SUBMISSION OBJECTING TO

Residential flat building with in-fill affordable housing

35-39 Darley Street East, Mona Vale | SSD-113872990

SUBMITTER	John Dorrington	POSITION	Object
CAPACITY	Mona Vale resident	EXHIBITION CLOSES	3 August 2026

PLA-DA-4100

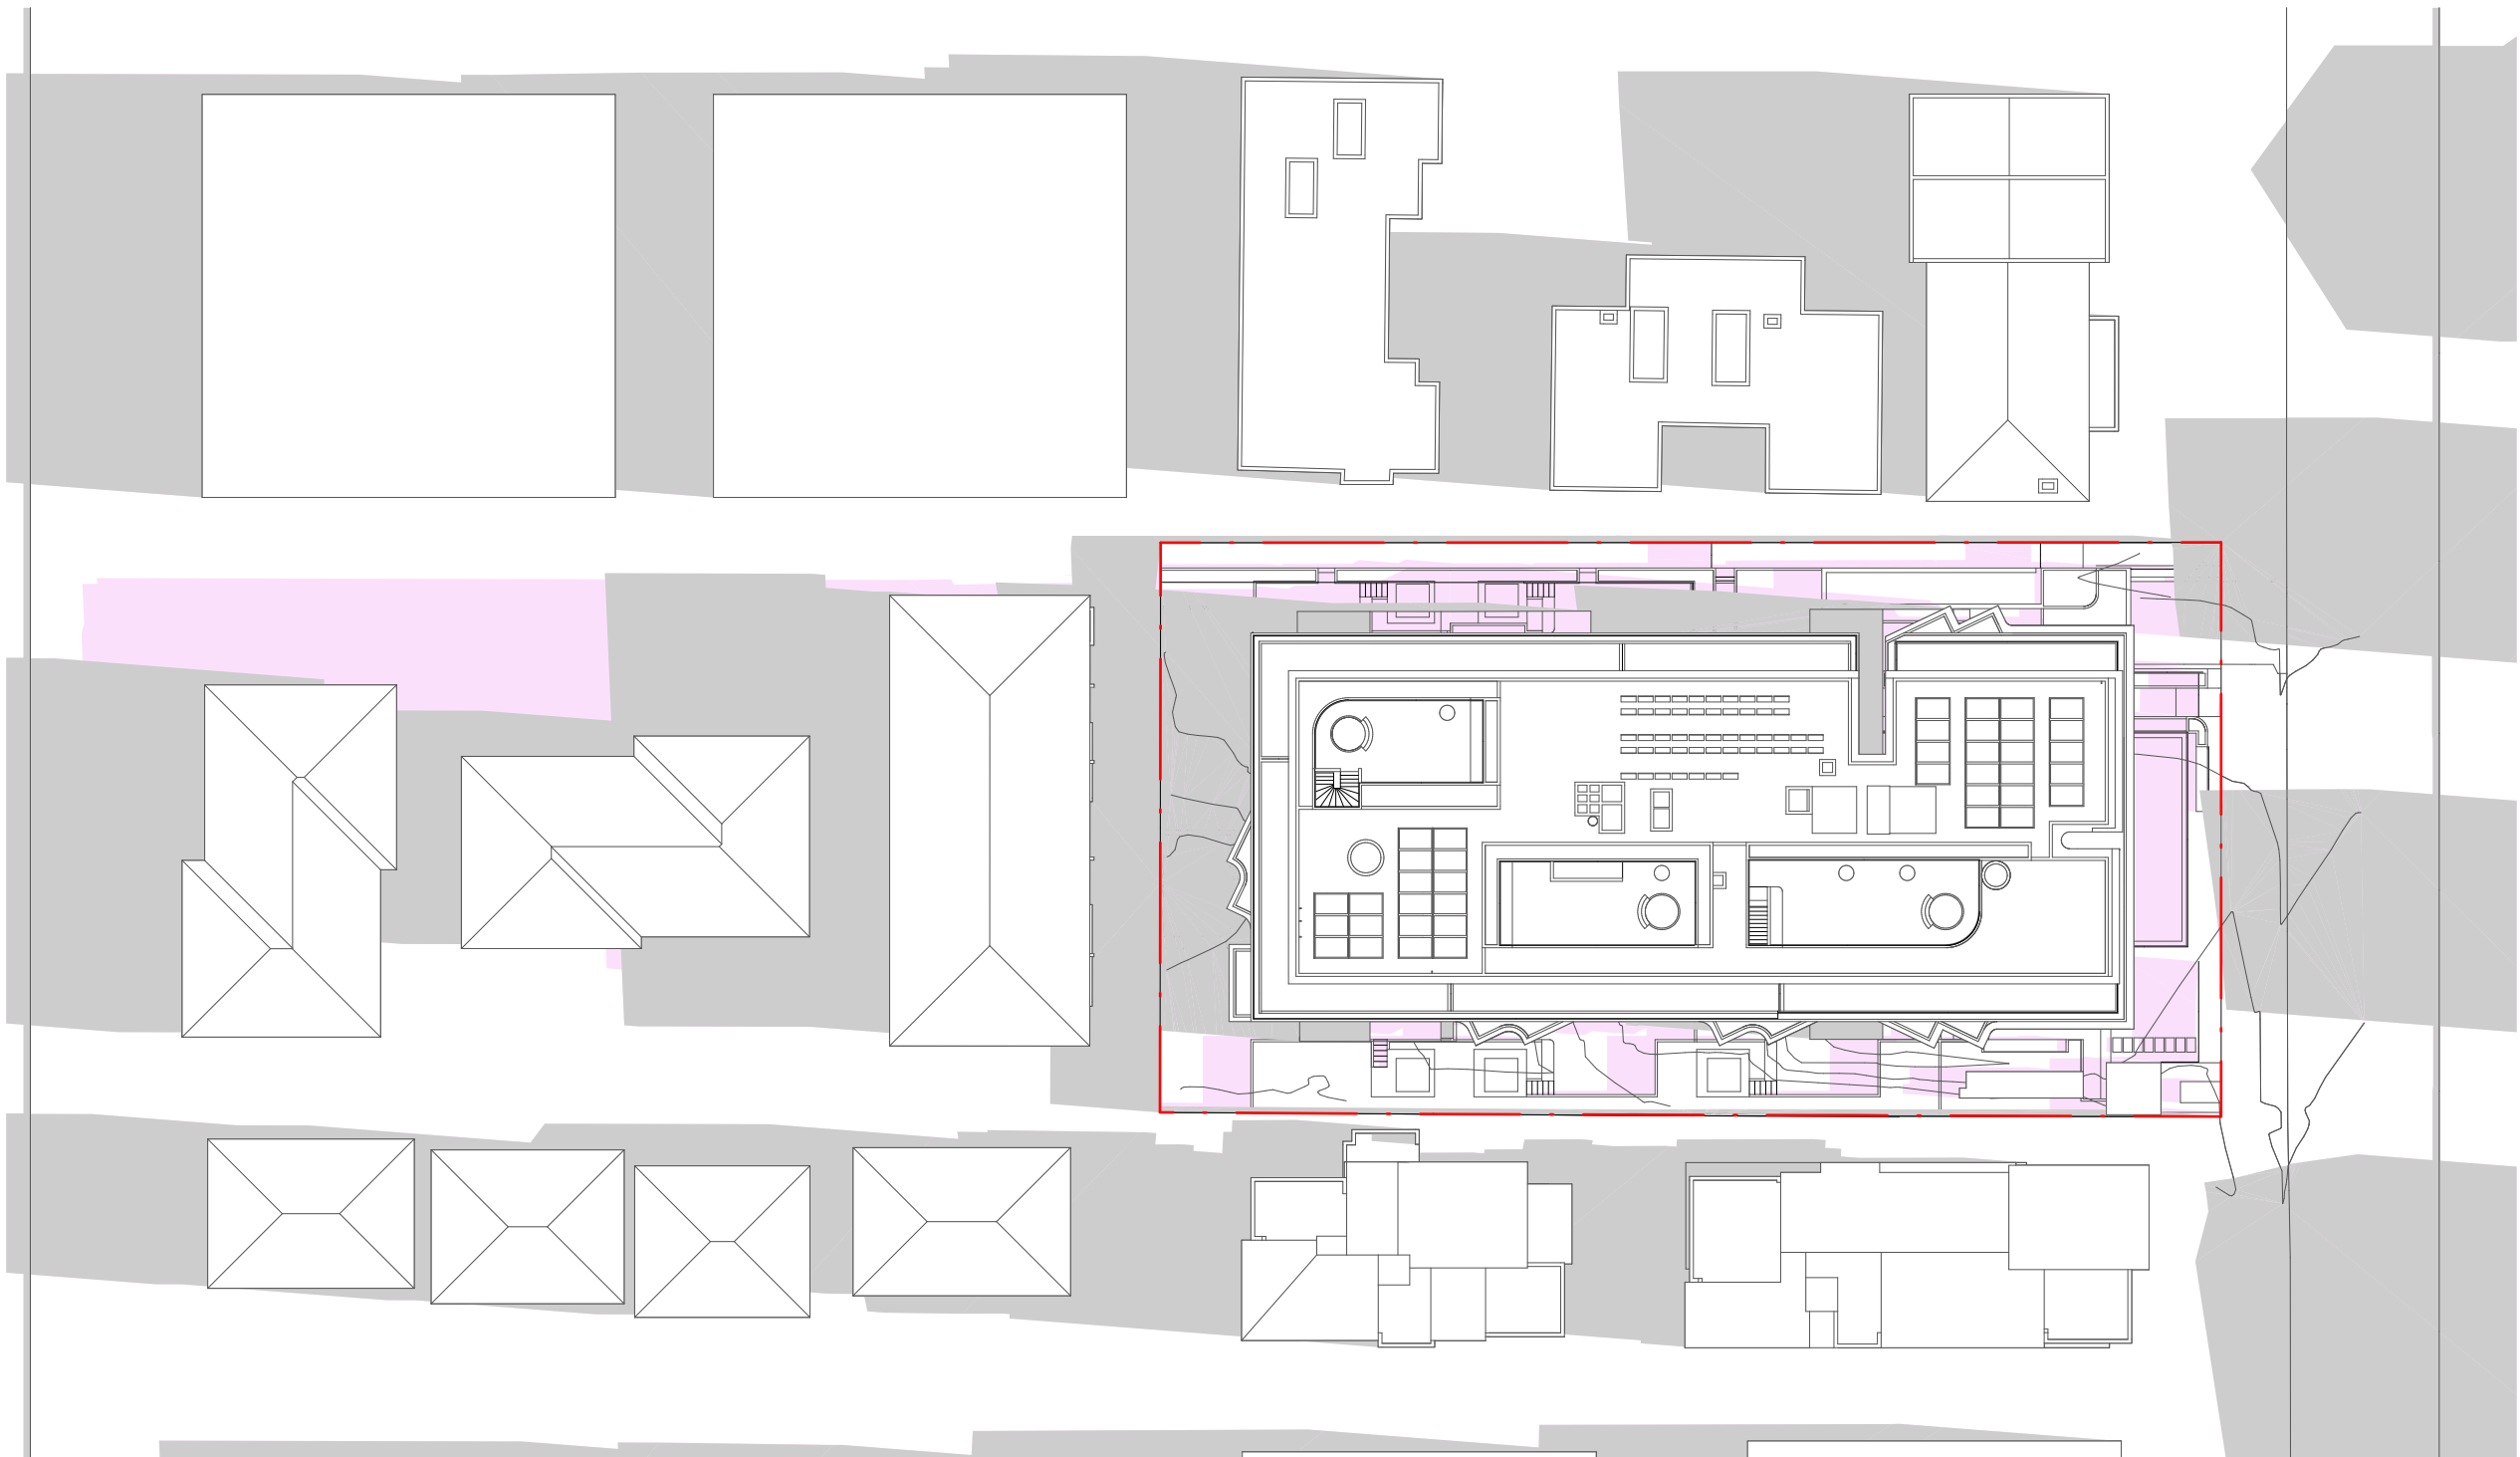
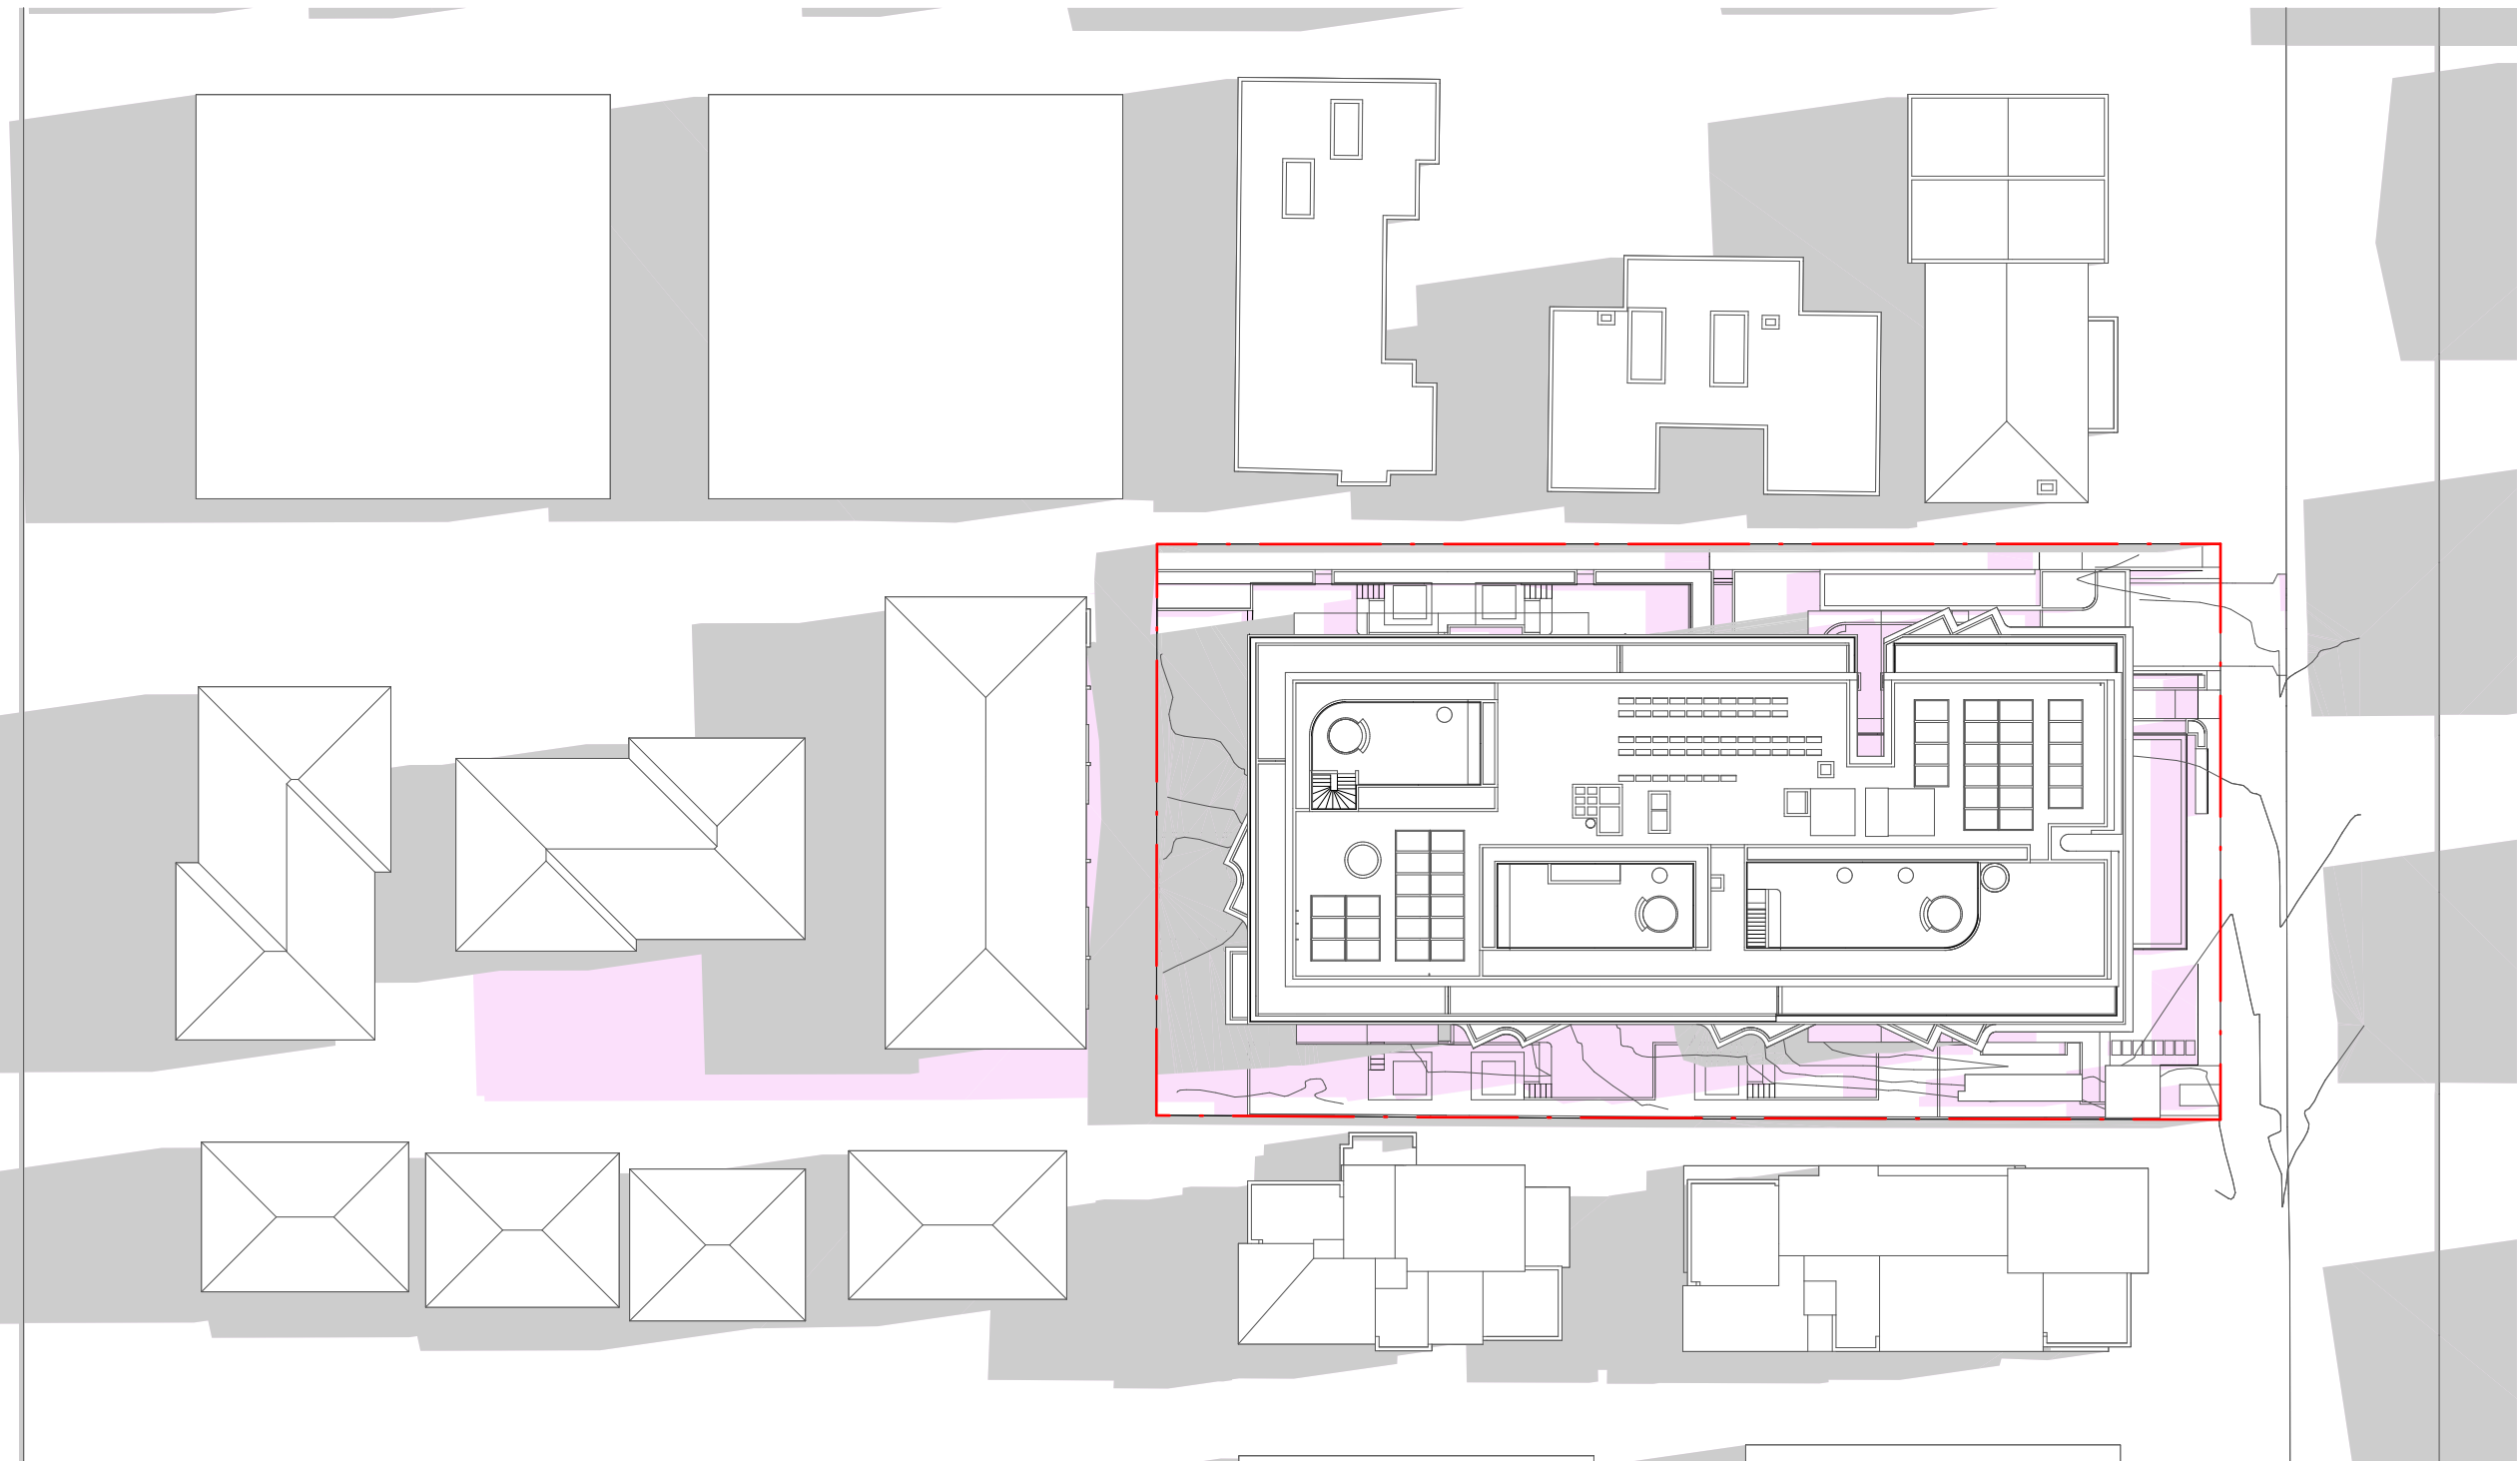
The EIS also concedes that overshadowing is unavoidable and identifies impacts to 28-30 and 32 Golf Avenue, 25-31 and 33 Darley Street East, with additional afternoon shadow extending to 34-36 Golf Avenue. Architectural shadow drawings PLA-DA-4100 and PLA-DA-4101 show new shadow extending across neighbouring land from 9 am through 3 pm on 21 June. The drawings do not support any suggestion of 'no impact'.

Before determination, the Department should require an independent peer review of the shadow model, quantified results for every affected dwelling and private open space, and a comparative analysis demonstrating the reduction achieved by deleting the upper two levels. Additional shadow should not be dismissed merely because a bonus exists.
